CITY OF ALBUQUERQUE
PLANNING DEPARTMENT
Development Review Board
May 26, 2004 Comments

PROJECT # 1002571 APPLICATION # 04-00776

RE: Lots 11-17, Sunrise Heights Addition/sketch

ALTA/ACSM Land Title Survey
 for
 LOTS 11 THROUGH 17 INCLUSIVE
 SUNRISE HEIGHTS
 ALBUQUERQUE, BERNALILLO COUNTY,
 NEW MEXICO
 MARCH 2003

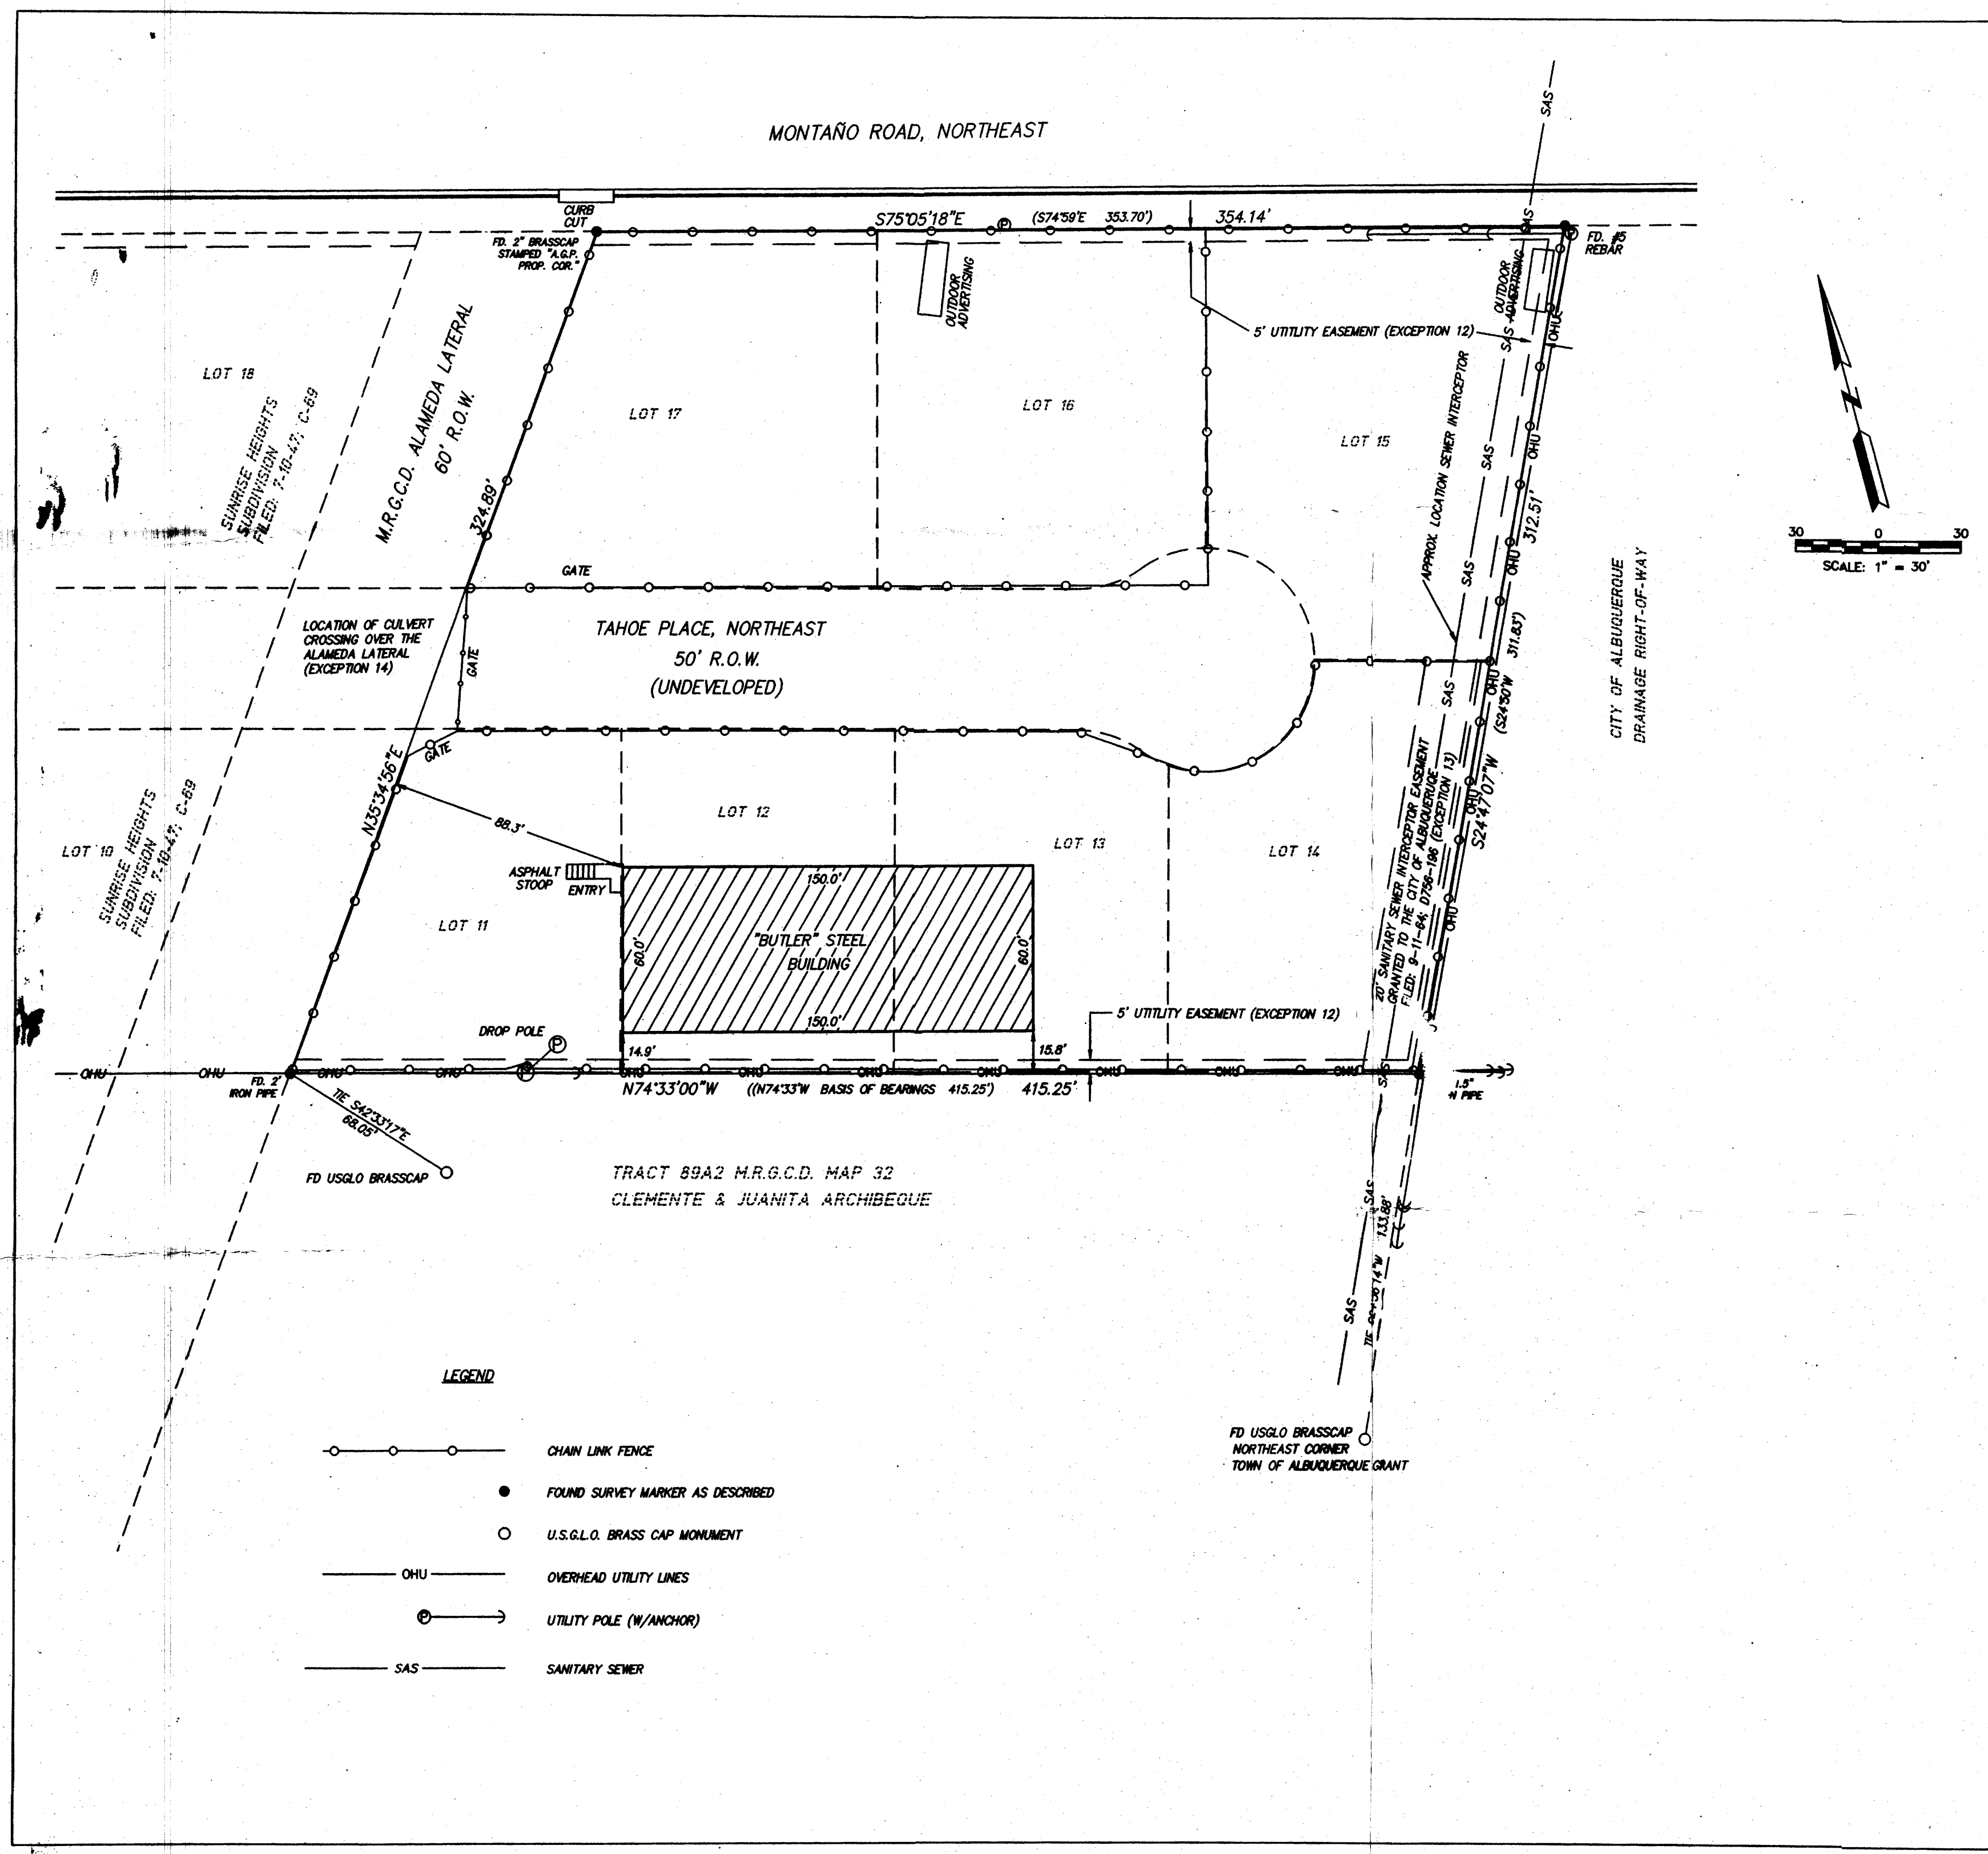
1. Will need to request a water/sewer availability statement once development plans are available.
2. Will need to dedicate a public sanitary sewer easement for the existing 48" sewer interceptor across existing Lot 15.
3. Sanitary sewer service is only available from Tahoe Place.
4. Water service and fire protection is only available from a 6" stub in Montano, or the dead end 6" line in Tahoe Place. These may have to be looped to get adequate fire flows.

A consolidation plat is requested.
